14 December 2021

Your Ref: *FP/246/21/PL*

3rd Party Representation - 26 Felpham Road, Felpham, West Sussex, PO22 7AZ

WEST ELEVATION

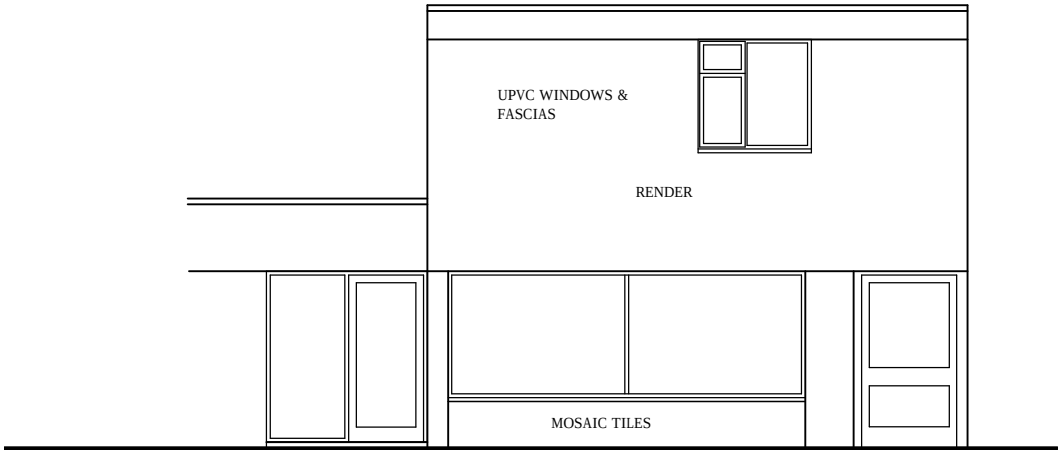
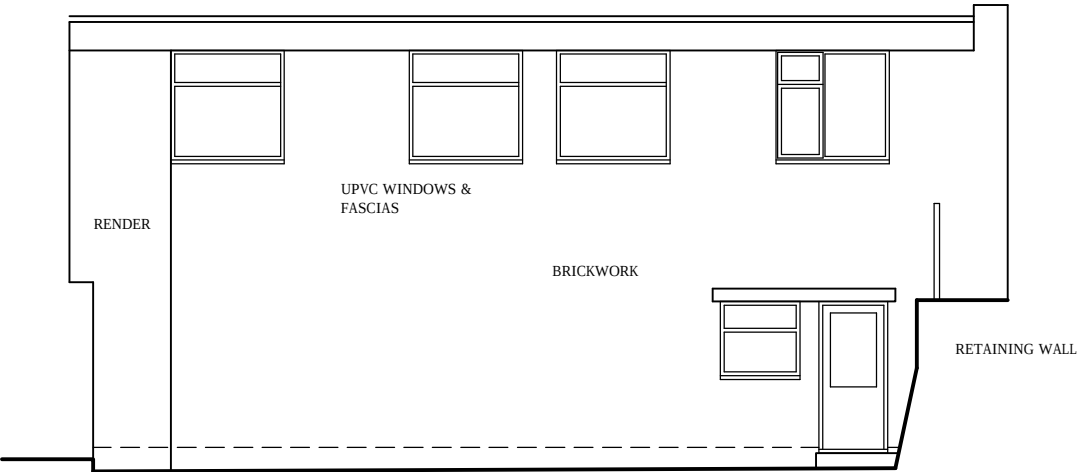
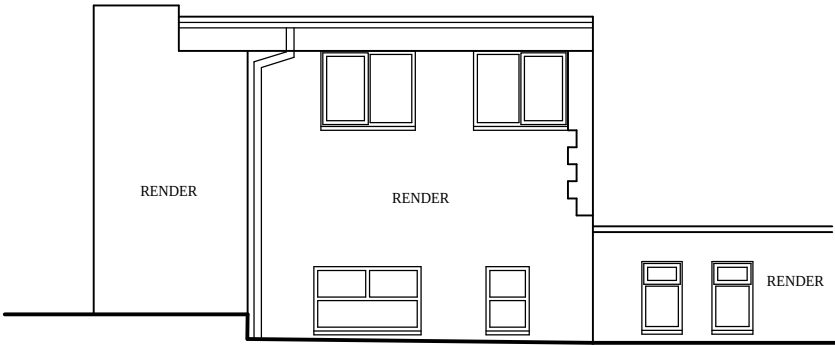
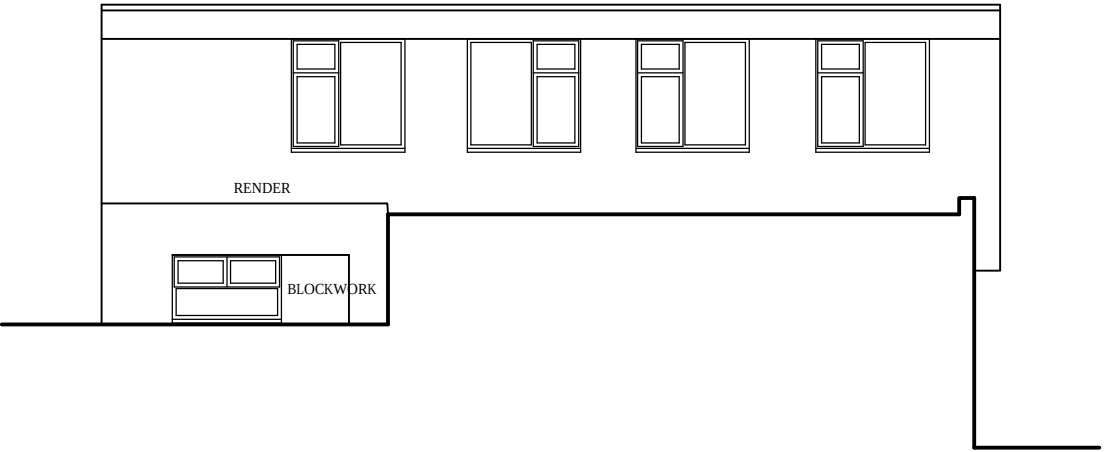
We would firstly point out that the flue is shown incorrectly on the proposed elevations. The flue is shown on the south side of the building on the west elevation, and the east side of the building on the north elevation. This leads to ambiguity in terms of the position of the flue. The ambiguity is also not resolved because the redline of the application site has excluded the flue (the redline is clearly shown running along both the south and east walls and not jutting out to include the flue notwithstanding the fact that the flue projects approximately 500mm from the wall).
